SSD-66826207 – Fiveways Site including affordable in fill housing.

Submission from: Wollstonecraft Precinct

Precinct objects to this SSD application:

Figure 3: 78.05m Height Plane Diagram (Source: Turner)

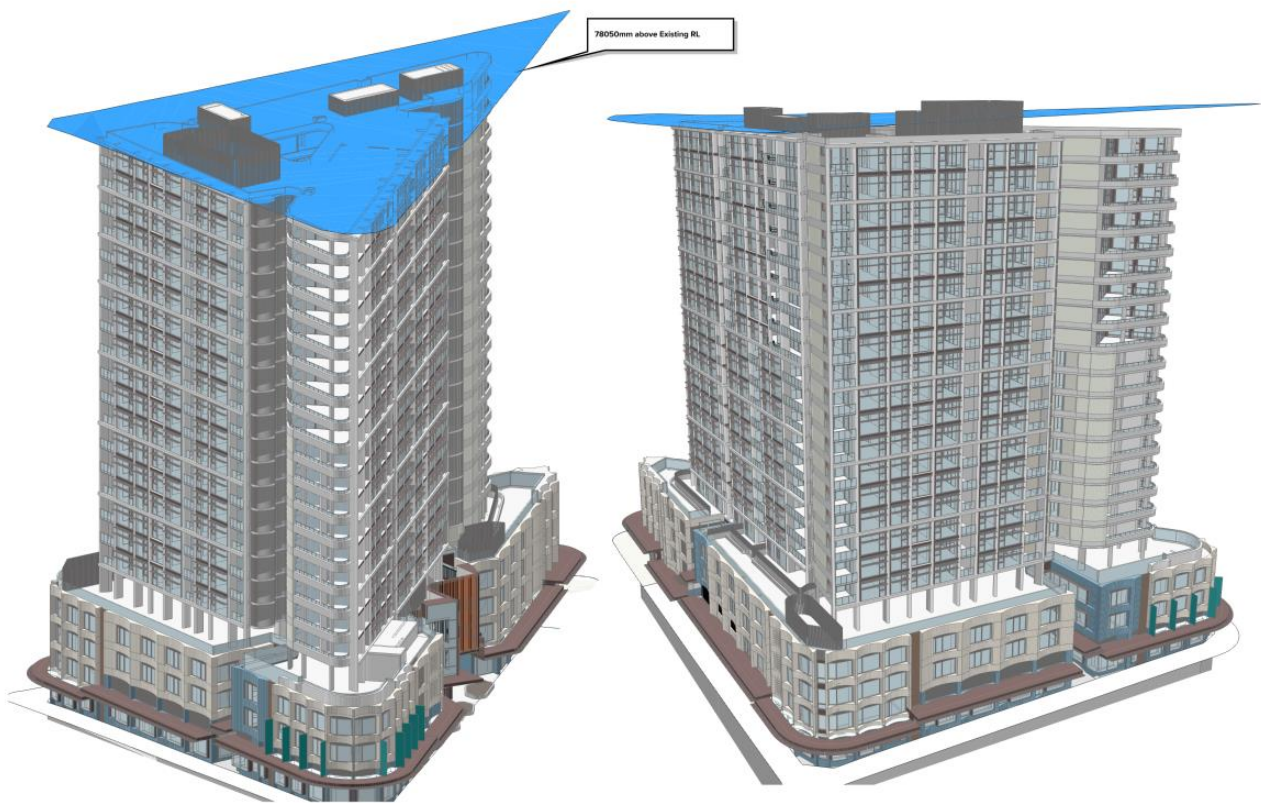
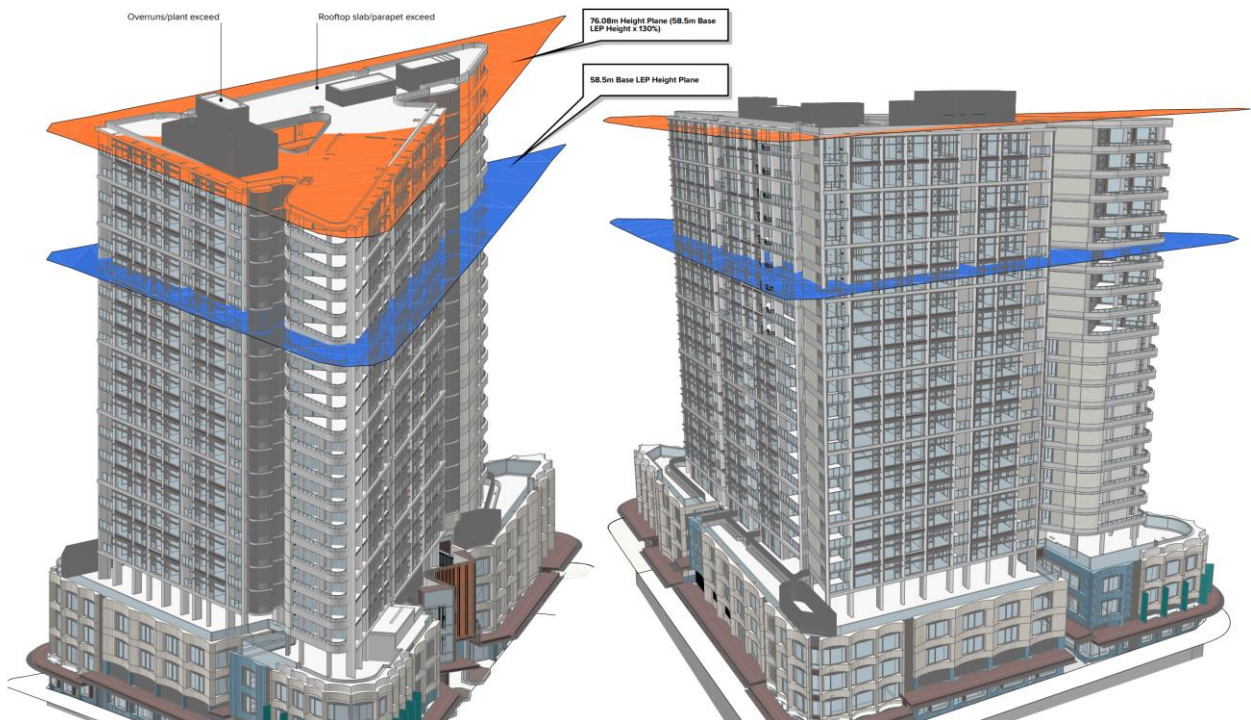
For the SSD application, the increase in height by four floors at 3.100 metres/floor would be 12.400 metres and the maximum allowable height for the new SSD application would be 58.5 + 12.4 = 70.9 metres (RL 169.00).

The 7m difference between maximum allowable height and the applicant's proposal can be seen in the new podium design. The bonus provisions of in-fill housing does not give license to the applicant to make other changes that push the height beyond the maximum height allowable.

So how does the applicant arrive at 191 apartments (48% more than the approved proposal) and a building height of 78.65m (RL176.0)? The simple answer is: The applicant has interpreted the SEPP provisions for in-fill affordable housing in a way that has taken advantage of the FSR applying to the whole of the land. It is acknowledged that the SEPP does say the whole of the land.

The maximum height also using the more logical interpretation of the SEPP would be 4 floors equal to an extra height of 12.4m, thereby lifting the maximum height from 58.5m to 70.9m (RL169.0).

The podium, which has increased height in this new proposal compared to the height incorporated into the already approved proposal, would need to be amended. The bonus provisions do not give license to the applicant to make major changes to any part of the design that push the height above the maximum allowable under the bonus policy.
